**PAVEMENT DESIGN REPORT
BRIARGATE PARKWAY SEGMENT 2
WHEATLAND DRIVE TO STERLING RANCH ROAD
EI PASO COUNTY, COLORADO**

PCD File No. CDR221

December 31, 2024

**FIG. B-10**

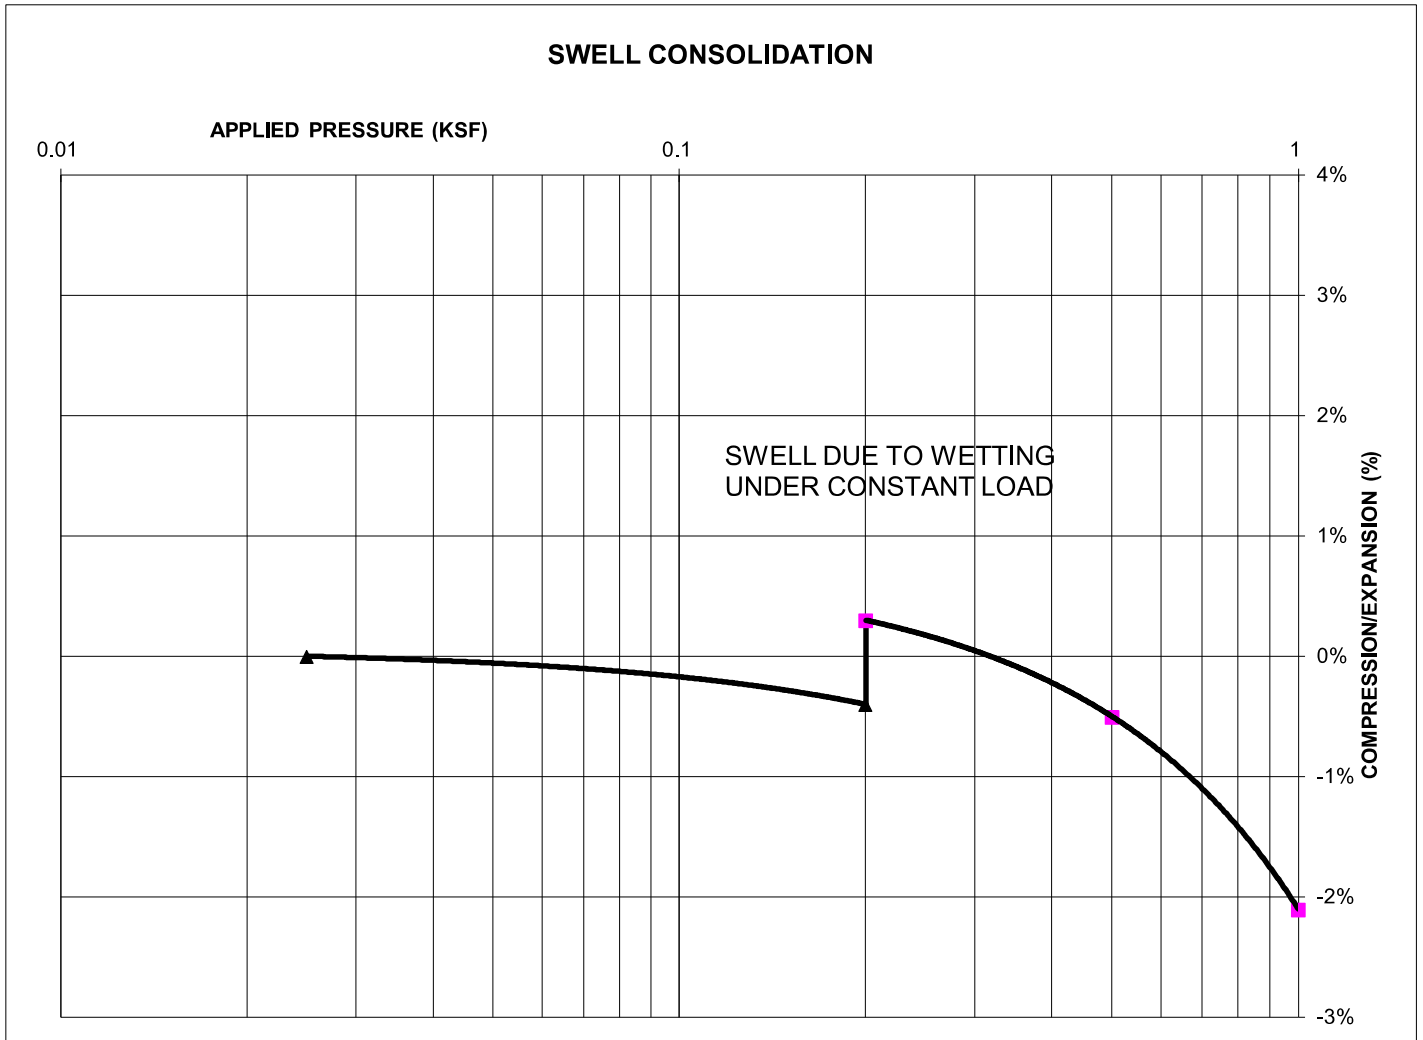
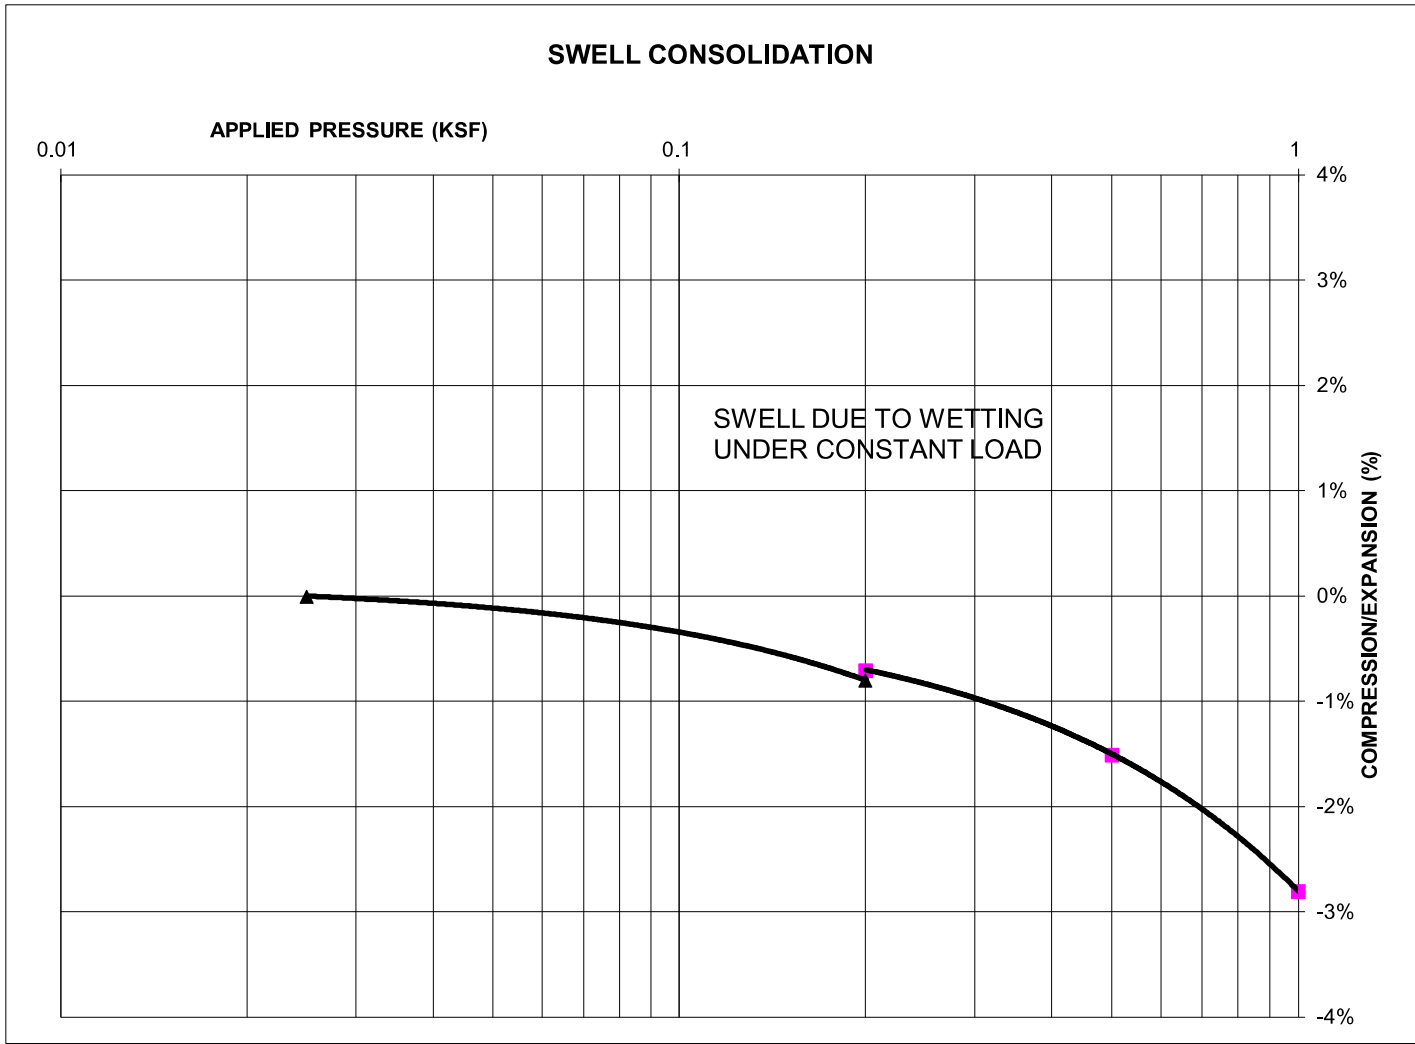
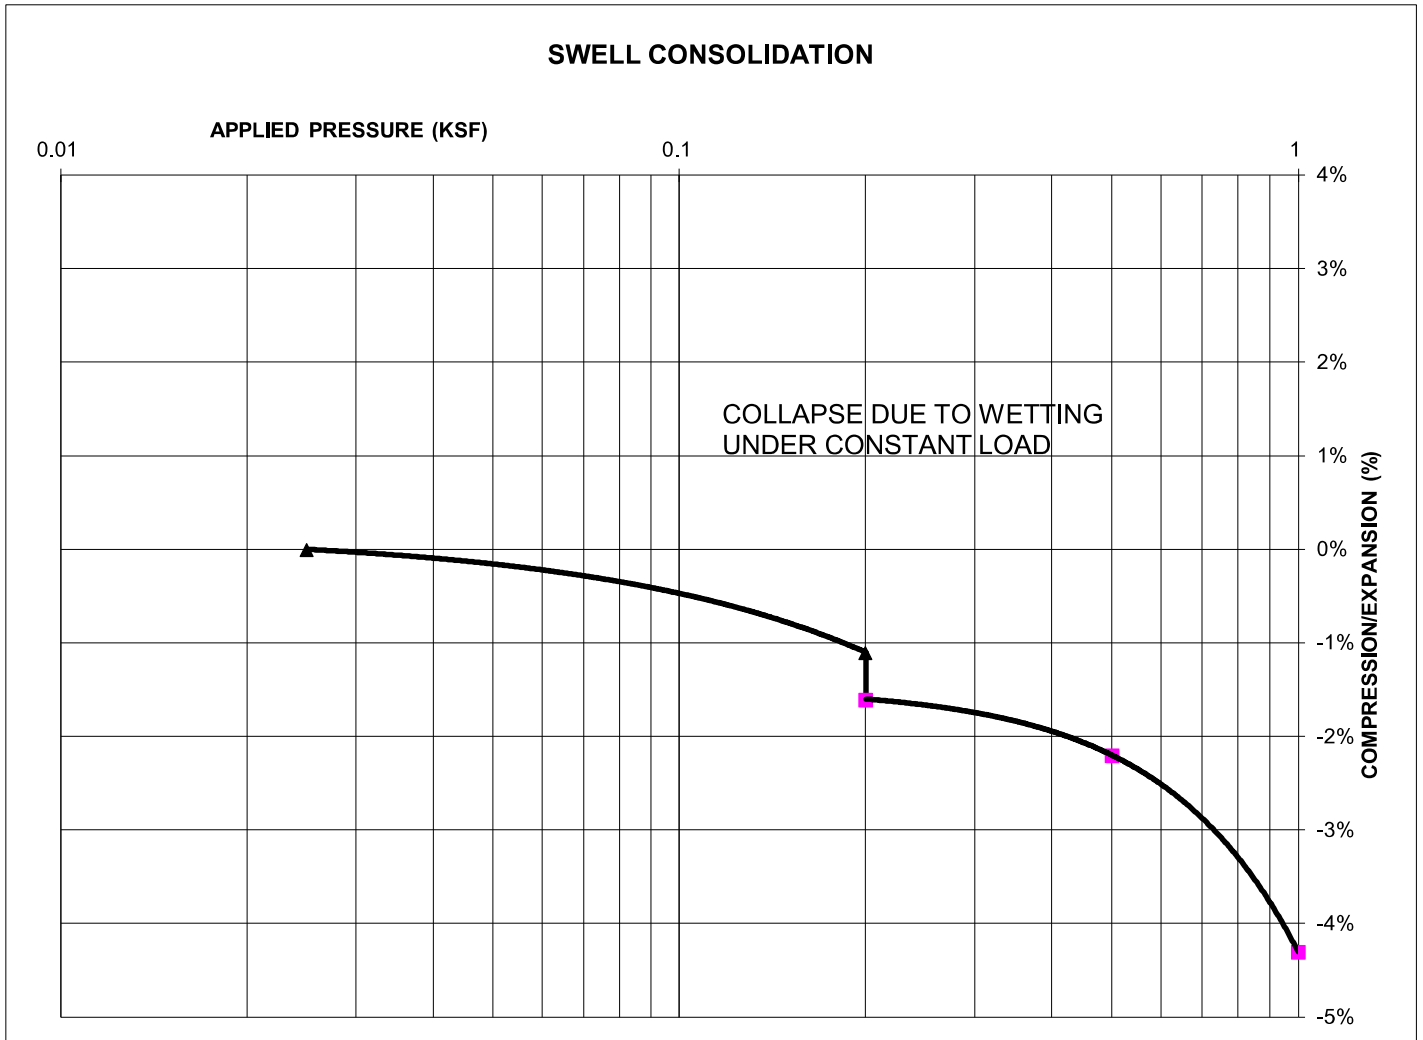
Address Swell potential for Type II soils.

Address swell for Type II

Type II soils do not meet CTS Criteria for PI index (PI>10) It is recommend that 18 inches of Type II soils are removed and replaced with Type I soils
